REF: TR010064

24th September 2024

REPRESENTATION: M60/M62/M66 Simister Island Interchange Project, National Highways

Drawing number: **HE548642 - JAC - GEN - STK**  
 Originator: **JAC** Volume: **DR-ZH-0006**  
 Location: **STK** Type: **DR** Role: **ZH** Number: **0006**

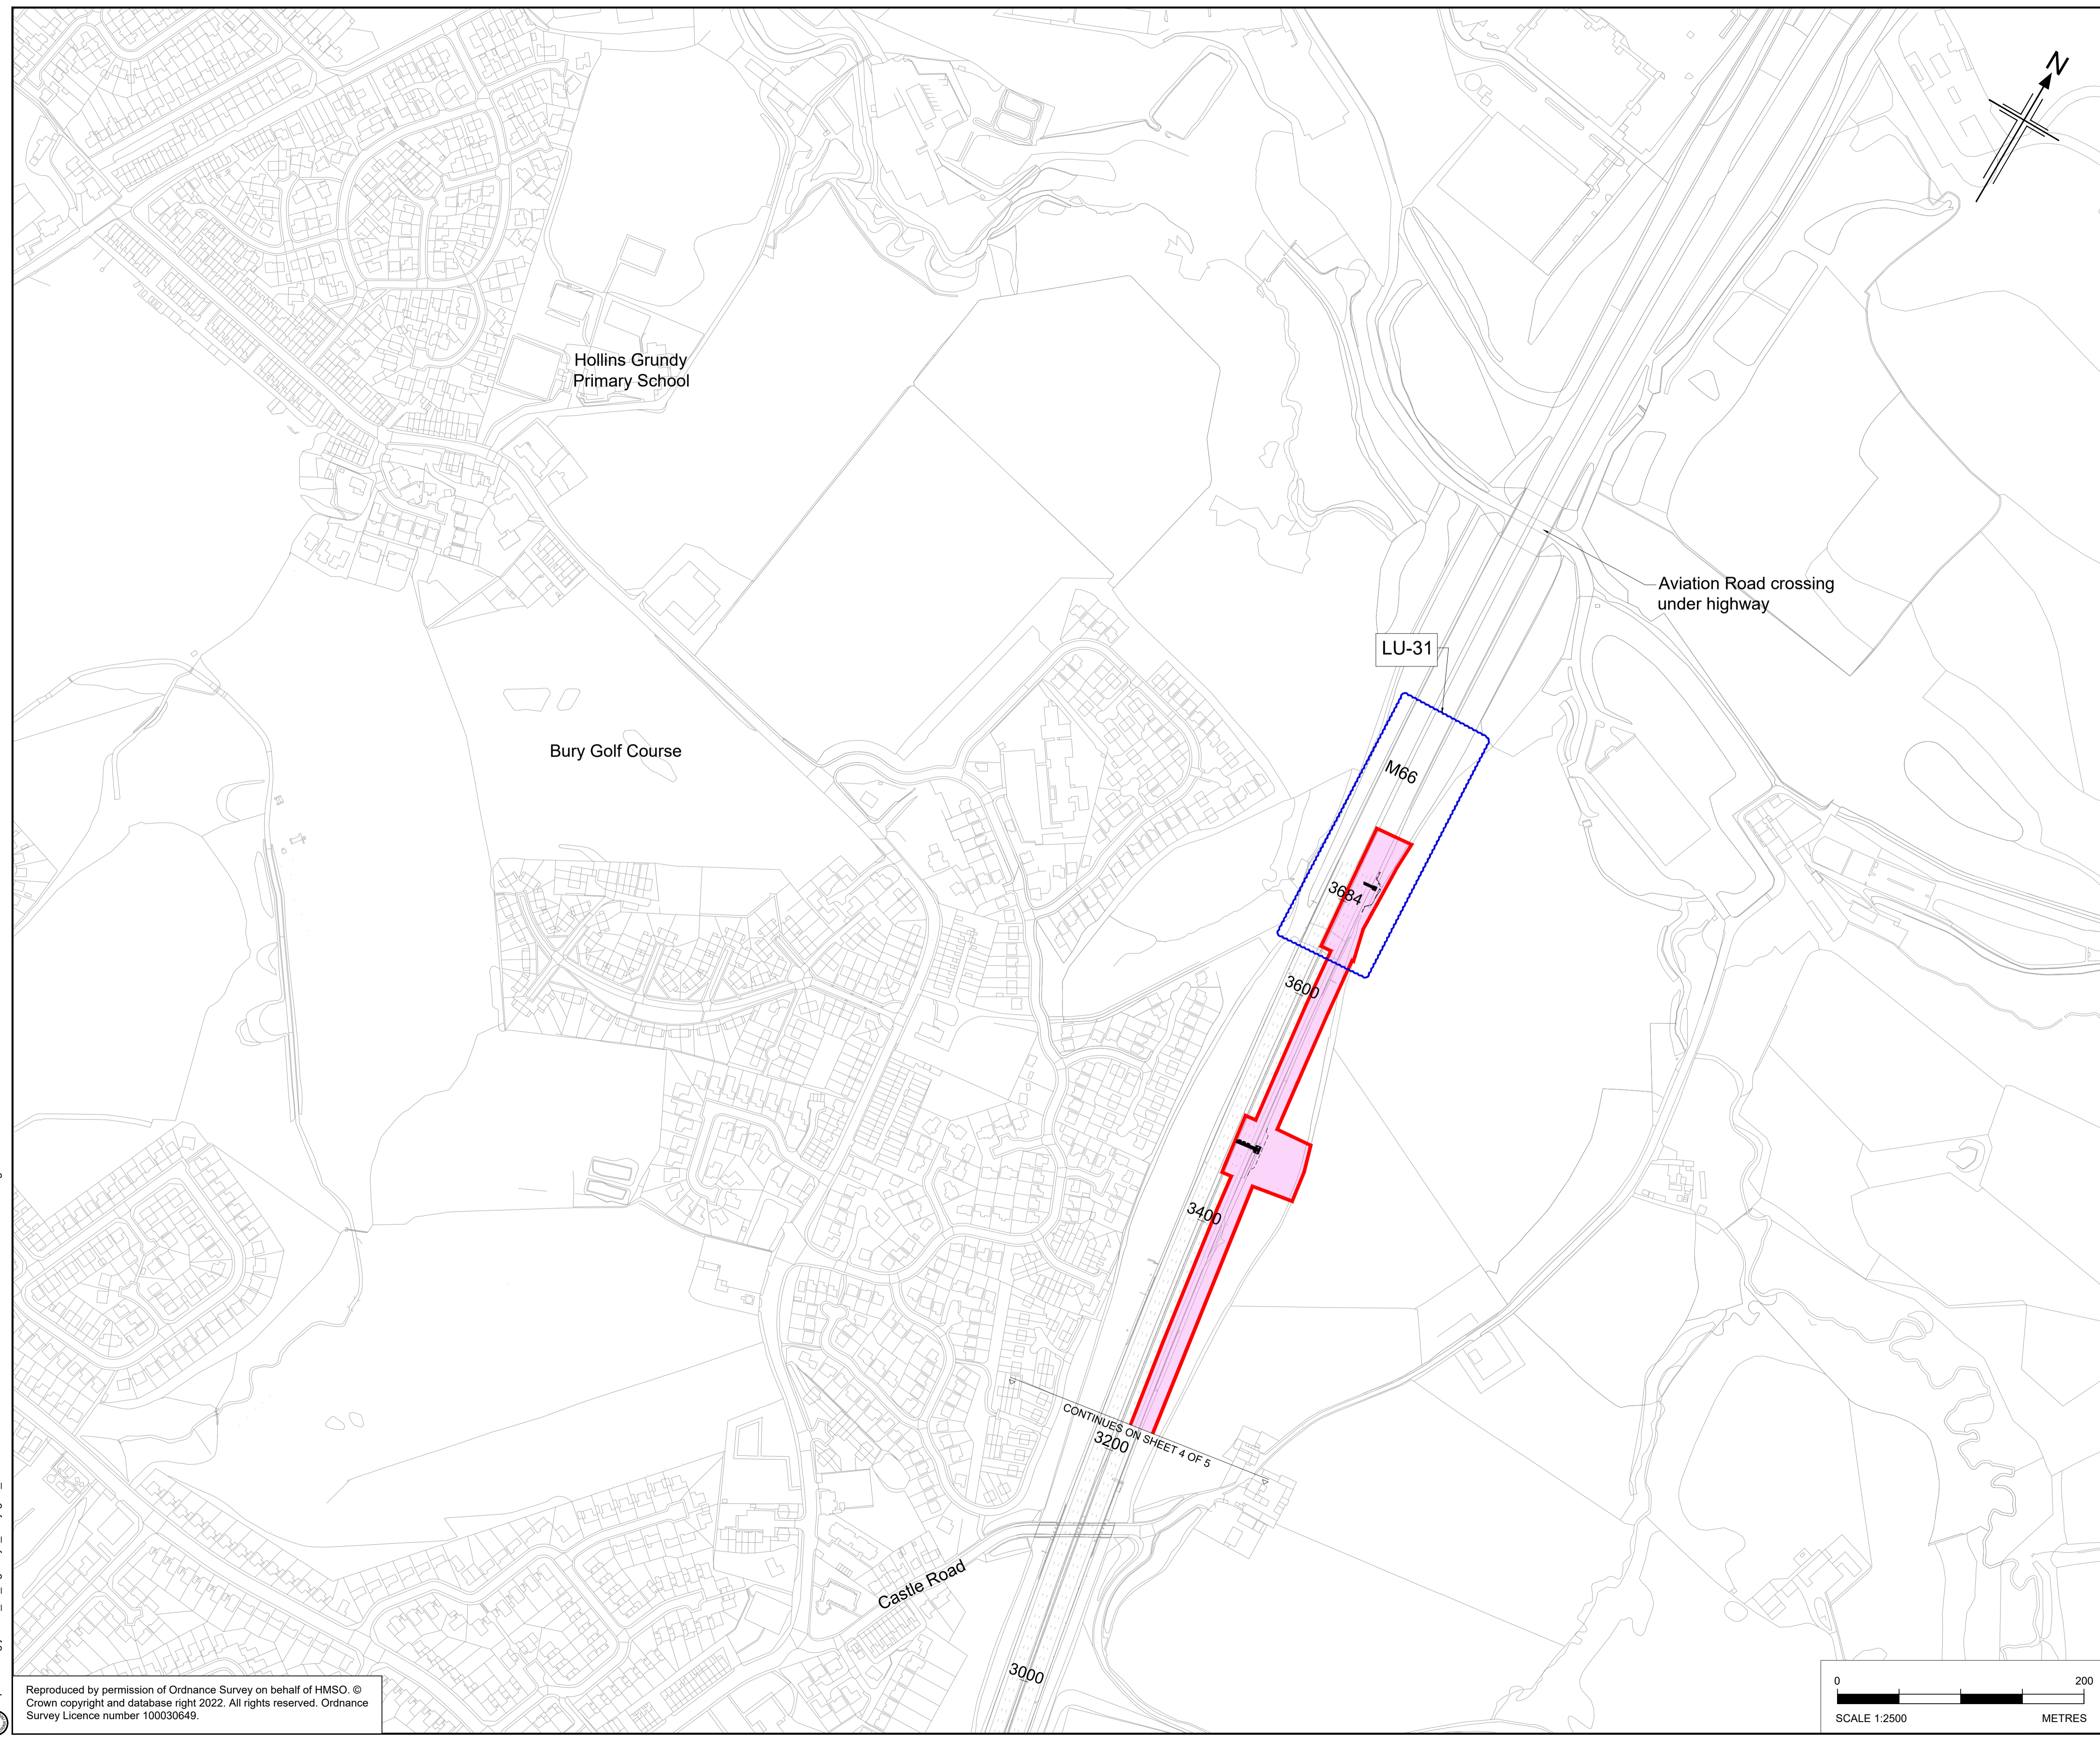
It is considered that National Highways has failed to robustly justify the proposed location for the attenuation pond proposed to the east of the M66, immediately east of the school playing fields which are located south of Griffie Lane (see *Land Use Plan Sheet 4 of 5 Drawing Number HE548642-JAC-GEN-STK-DR-ZH-0006*).

The Inspector is requested to consider the lack of robust evidence that a full assessment of alternative locations for this attenuation pond has been undertaken. Land immediately to the south of the playing fields or land to the immediate north of the strategic allocation offer locations closer to the M62/M66 itself (thereby negating the need for easements across land to the motorway, as is proposed), and also offer the opportunity to reduce the impact on developable land. While the burden to carry out such a sequential assessment of alternative locations does not fall on my client, it is the case that the applicant here has failed to explore this to the full extent.
